CITY OF ALBUQUERQUE

August 28, 2014

**Re: La Vista Subdivision
Grading and Drainage Plan
Engineer's Stamp Date 6-17-14 (C19D042A)**

LEGAL DESCRIPTION:
LOT 17, BLOCK 1, NAA, TRACT 2, UNIT 3, CONTAINING 0.7277 ACRE

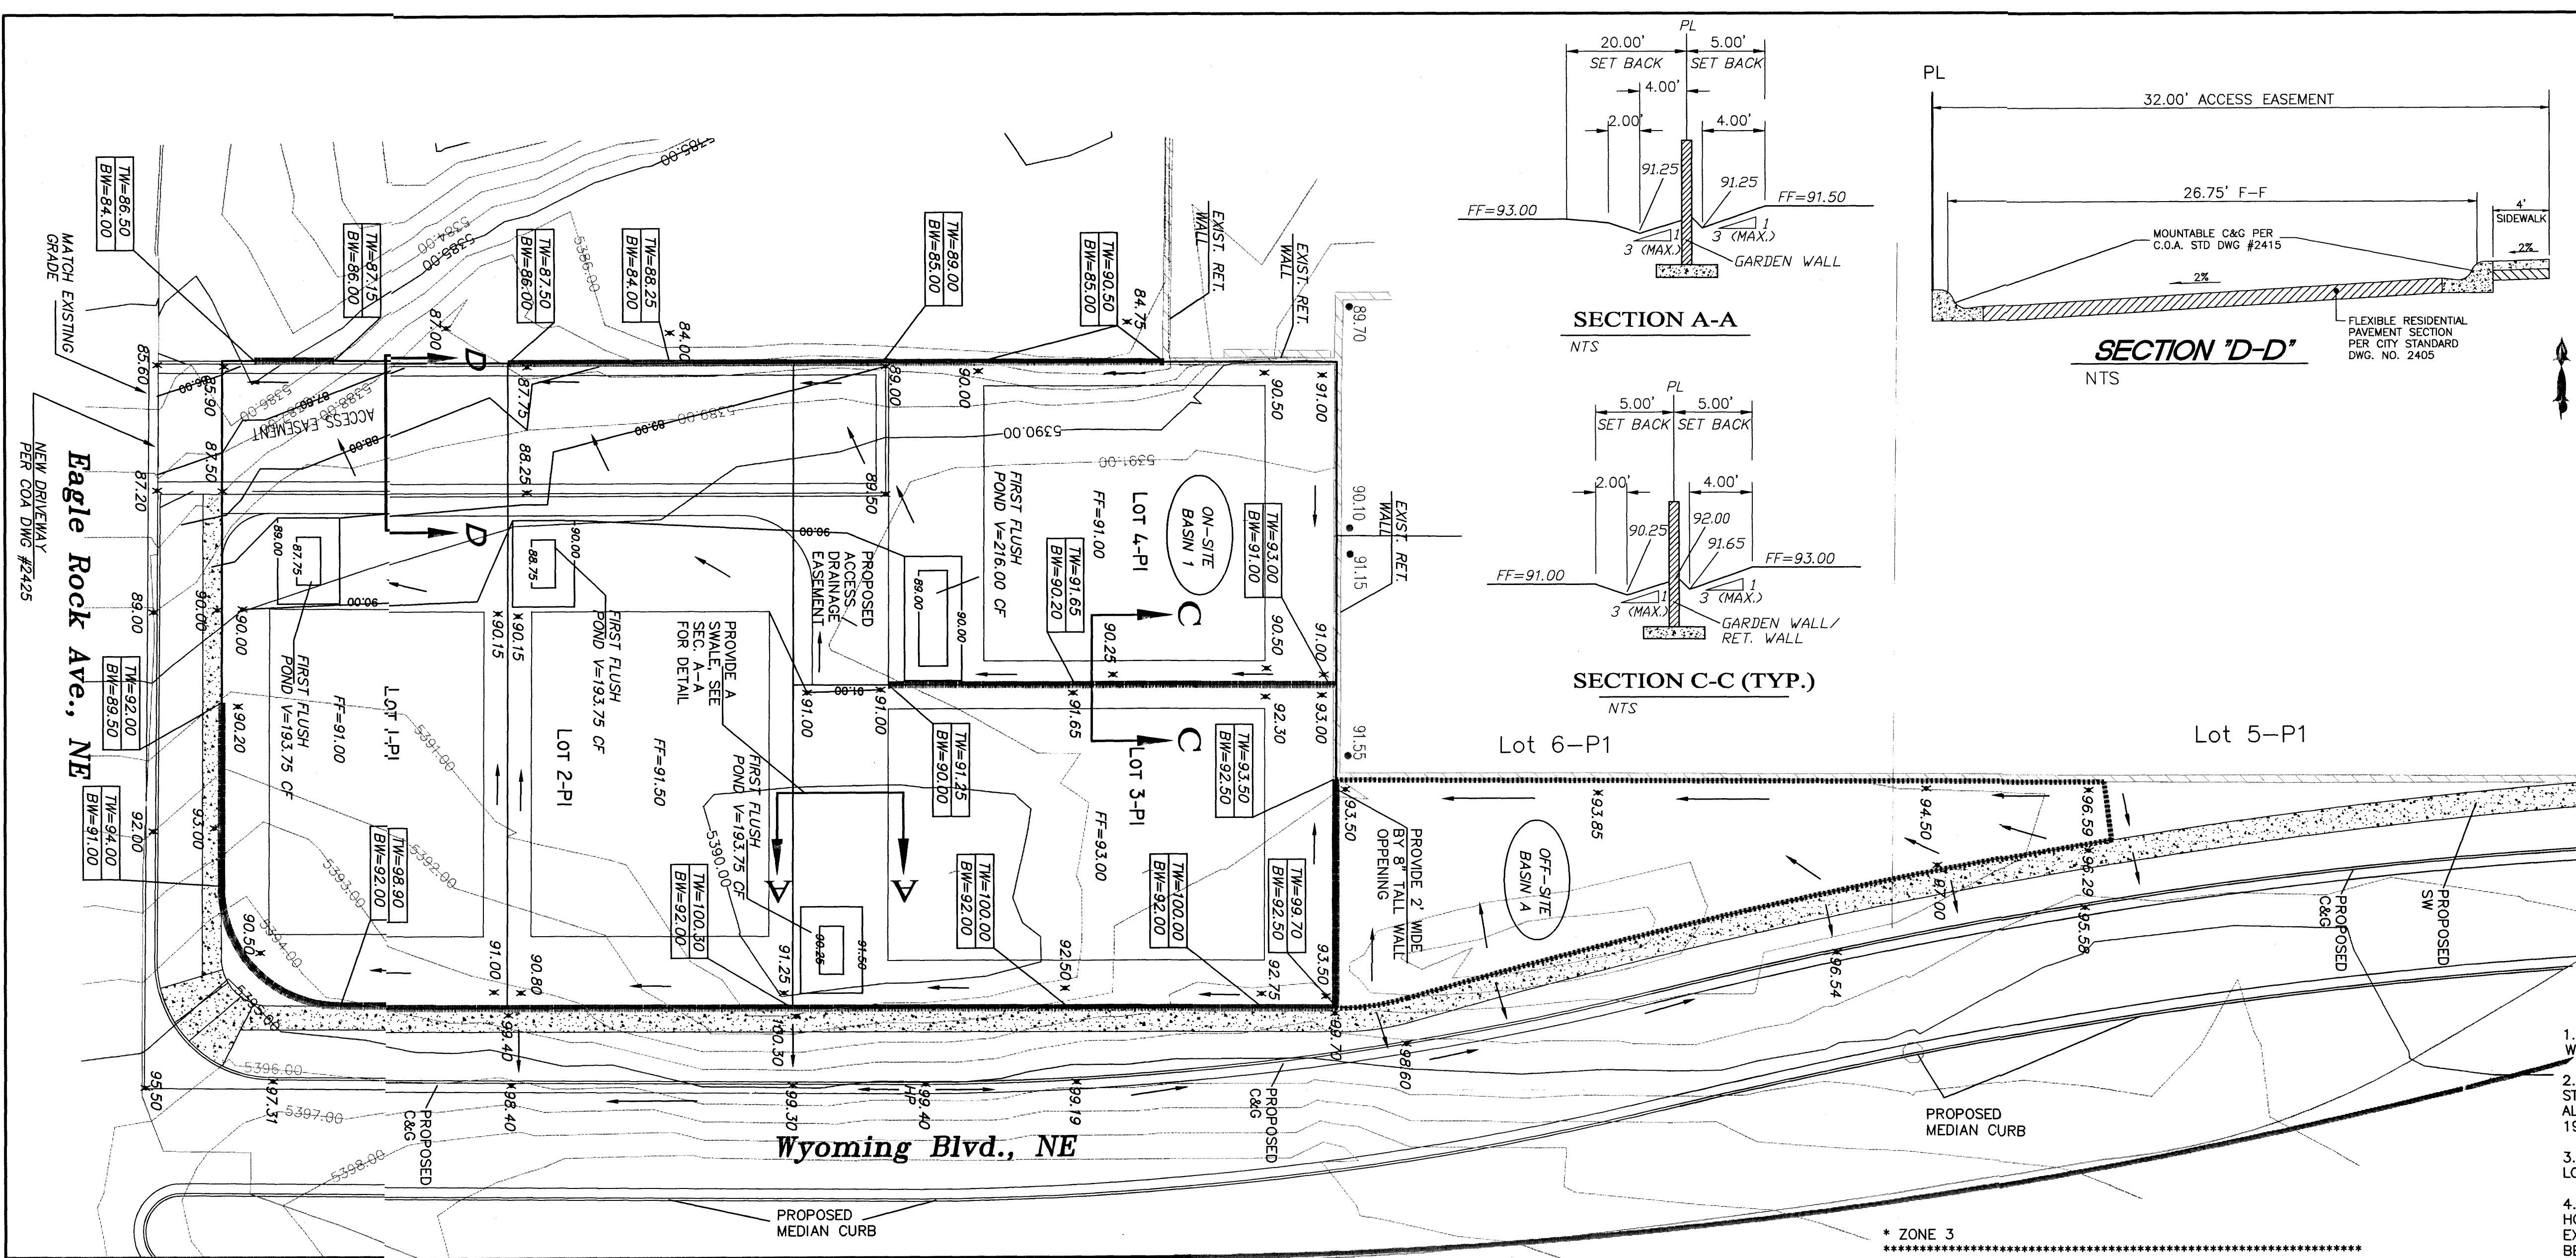
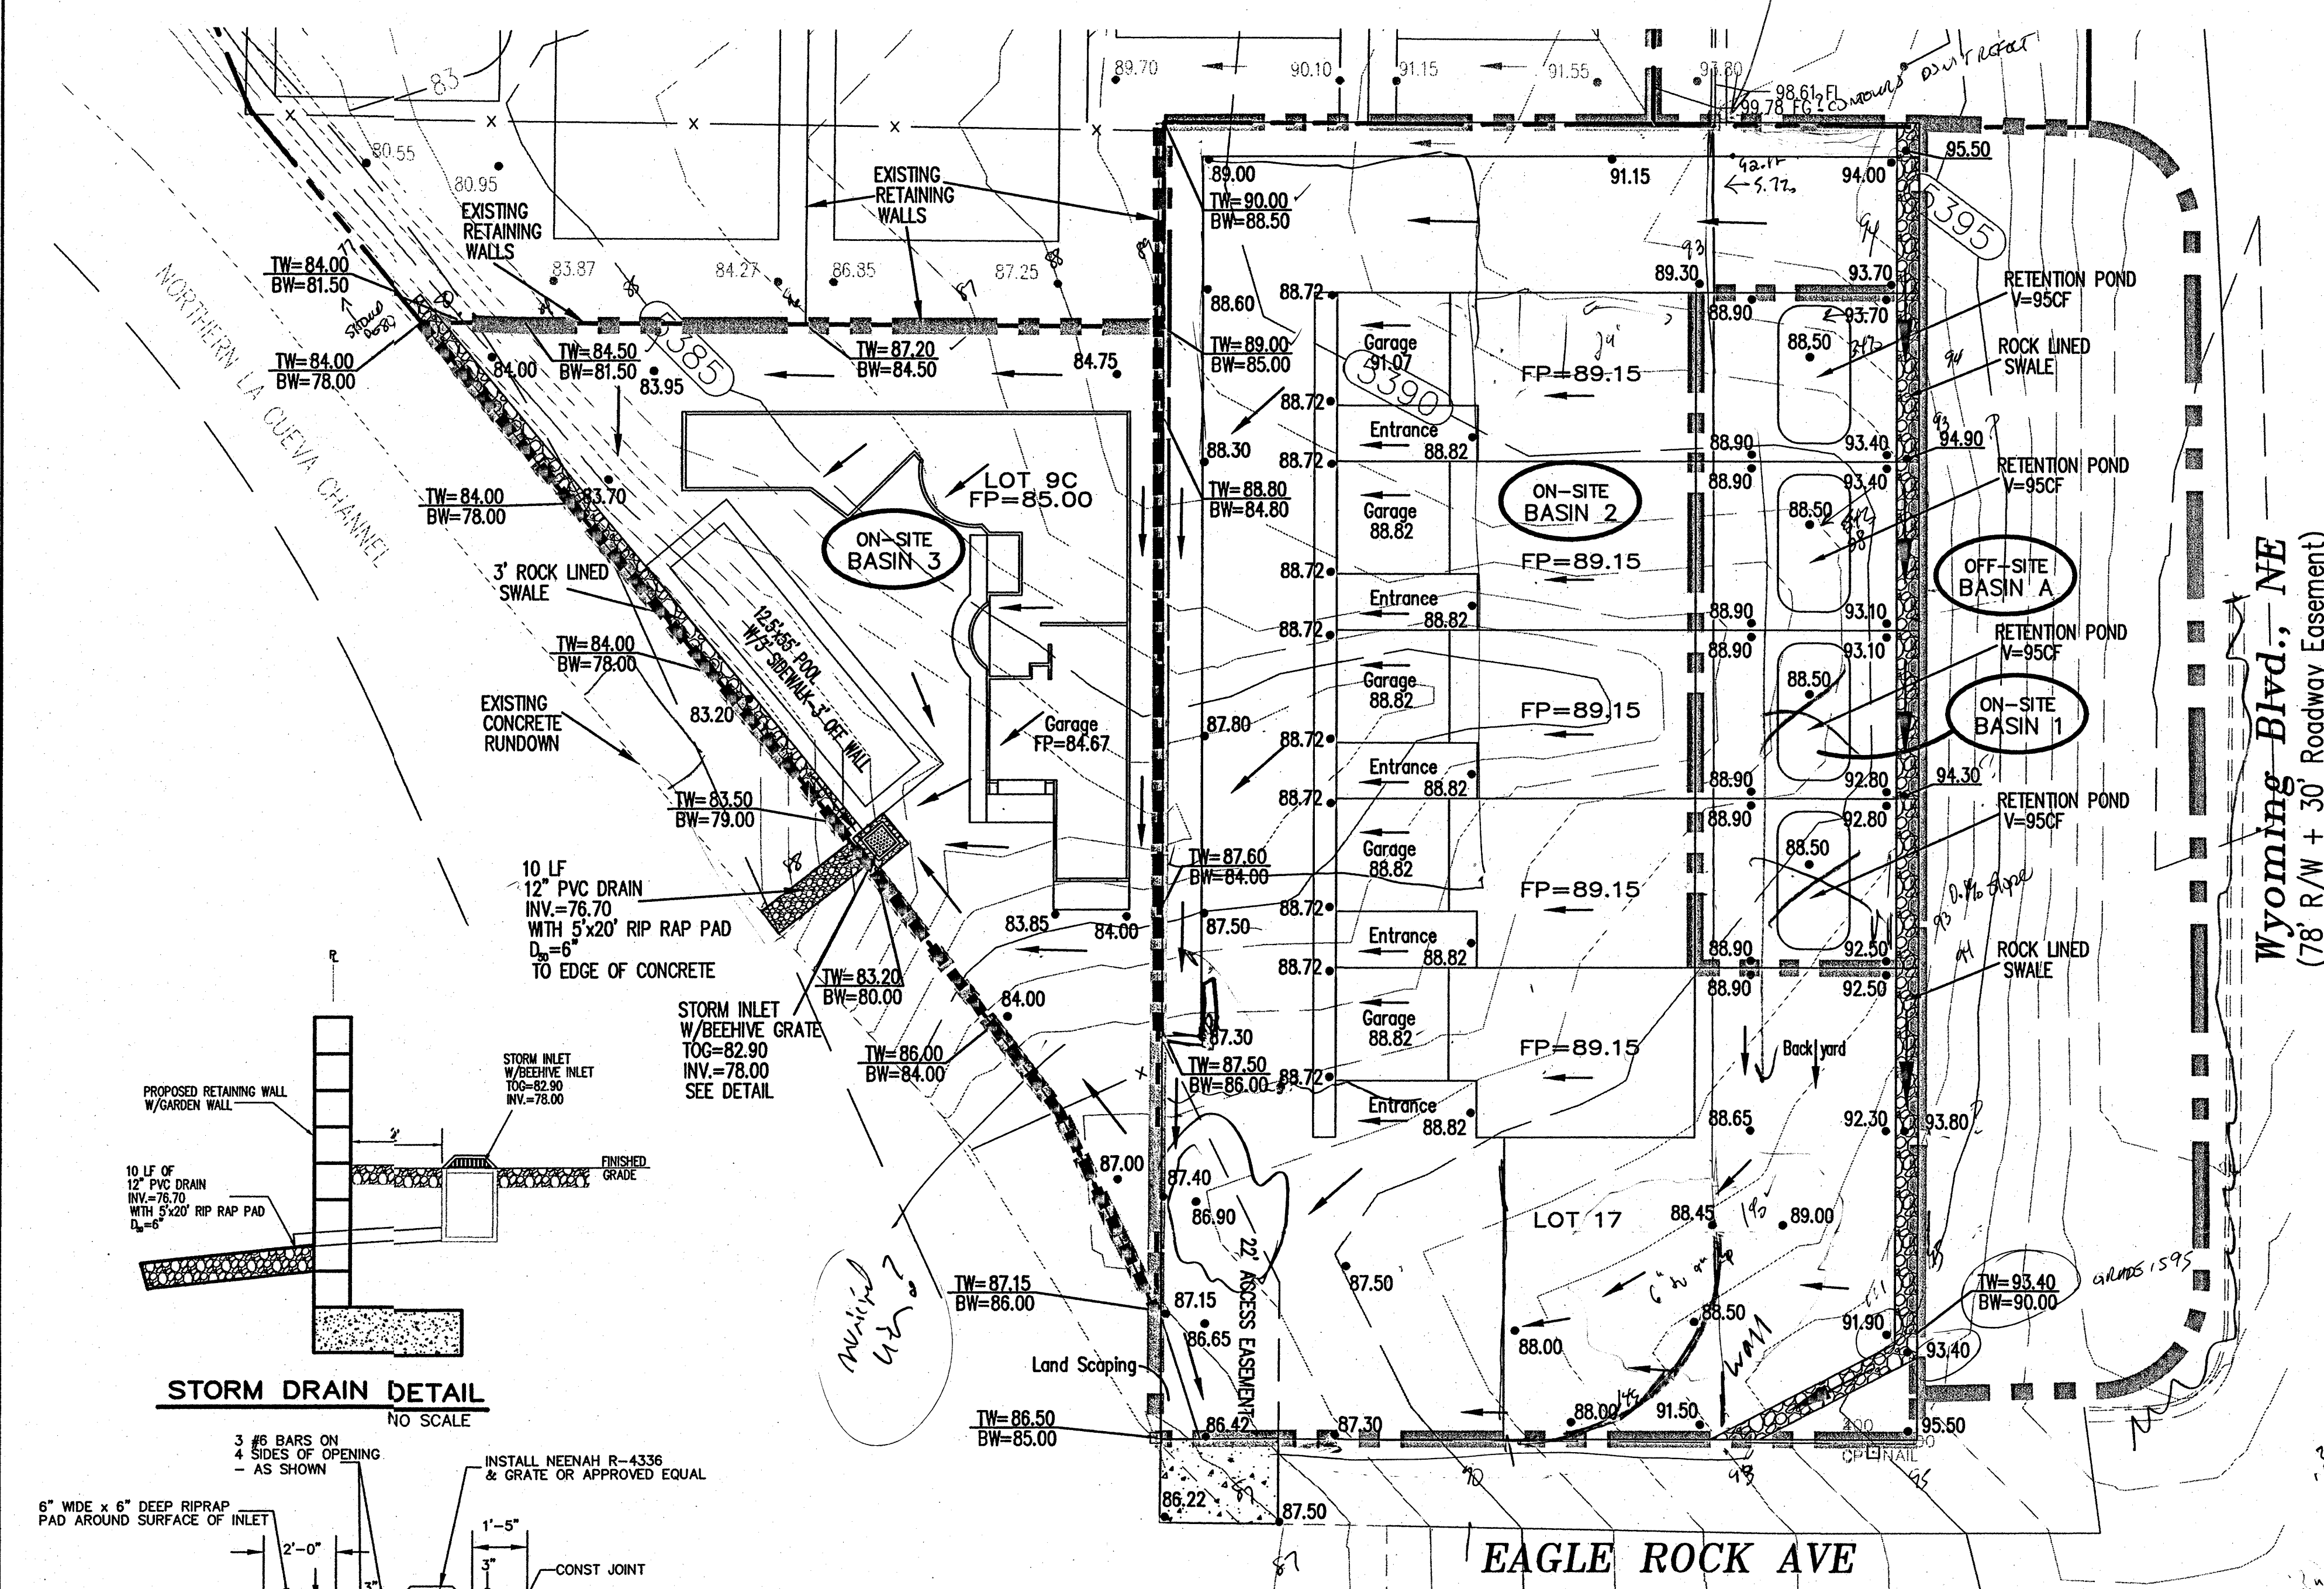
1. Determine the size of the Basin B in the final condition with a redesign of Wyoming east of the constructed La Vista Subdivision. Since the redesign of Wyoming east of Lot 17 is no longer necessary, the proposed design for Wyoming submitted with the interim area of Basin B is no longer practical. Provide a redesign of Wyoming east of the constructed La Vista Subdivision that shows the size of the final Basin B. Design Lot 17 for the larger flow and volume whether or not those are due to the interim condition or final condition.

2. Based upon emails forwarded by you from AMAFCA, AMAFCA is suggesting a French drain instead of draining into the channel. The French drain concept is acceptable to City Hydrology. Design the French drain for the 100 year 6 hour storm. An on-site percolation test will be necessary for that design. Revise your plan to show a French drain. Include the design calculations for the French drain.

3. At the southeast corner of the proposed pool on Lot 9C, surface water drains into the pool. Revise so water does not drain into the pool.
4. On Lot 17, the proposed driveway is not in alignment with the gravel driveway. Revise the alignment. The spots elevations of the southern end of the drive are not match the existing concrete drive. Revise the spot elevations. Add a curb or wall along the western edge of the driveway from the wall (elevation 87.5) to the southern property line of Lot 17. Extend the proposed concrete drive five feet north of the swale so the swale does not erode the driveway.

5. On the western edge of Lot 17, you are proposing 8-12% slopes the access easement to Lot 9C. While a water block is necessary, a smoother transition along the access driveway is also necessary.

6. Include the height of the wall opening on the north side of Lot 17.
7. A swale is drawn along the eastern edge of Lot 17. There is a 2 foot drop over 2 feet from the western edge of the swale to the spot elevation for the back of the yard. You have stated in conversation that a wall will be there. Show the wall on the drawings.

8. Walls will be separating the back yards. Show the walls and provide an opening for the back yards to drain through.
9. Provide spot elevations on the sidewalk.
